Ref. Comment on proposal ref. Parcel #558535:

LOT 9 HYAK ESTATES 2 GRADING DESIGN
RYAN PAZARUSKI
SITE PLAN

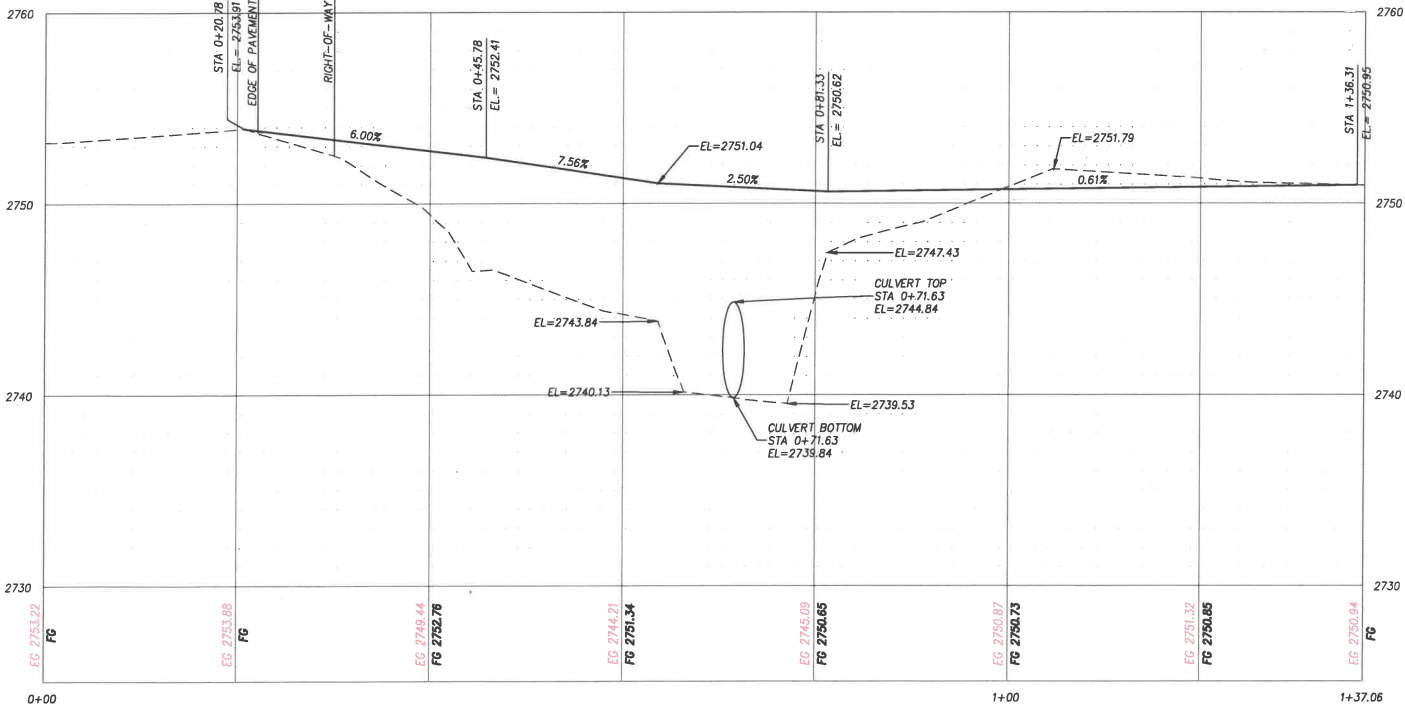
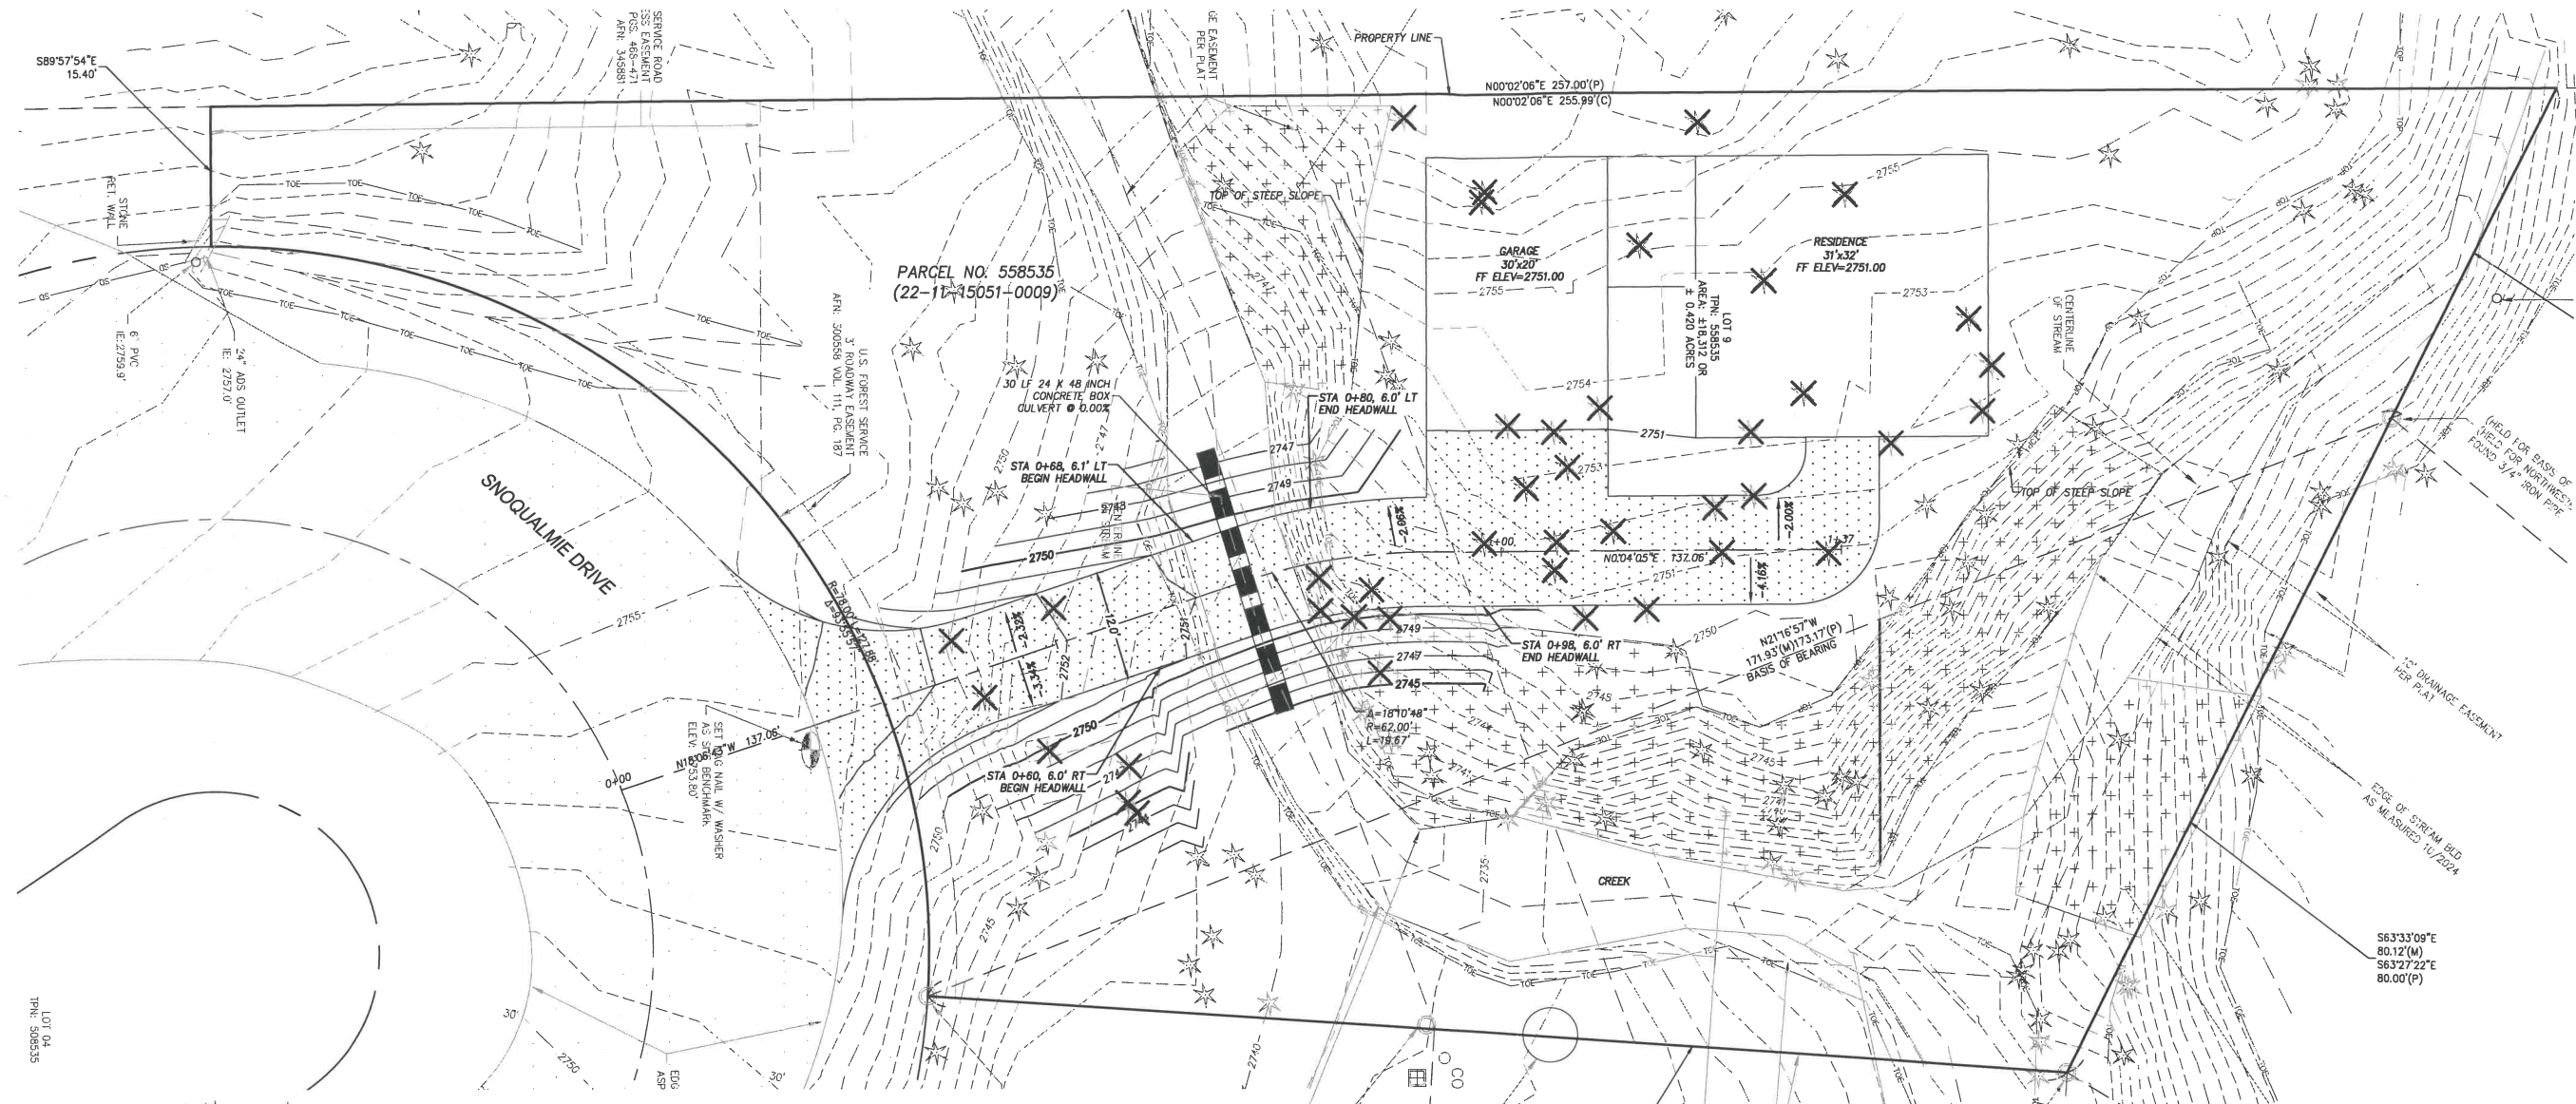
My concern would be the flow path of the stream, and whether the culvert is sized to prevent any change in that path.

There are no current water drainage issues on my property, and I hope the new construction does not change that.
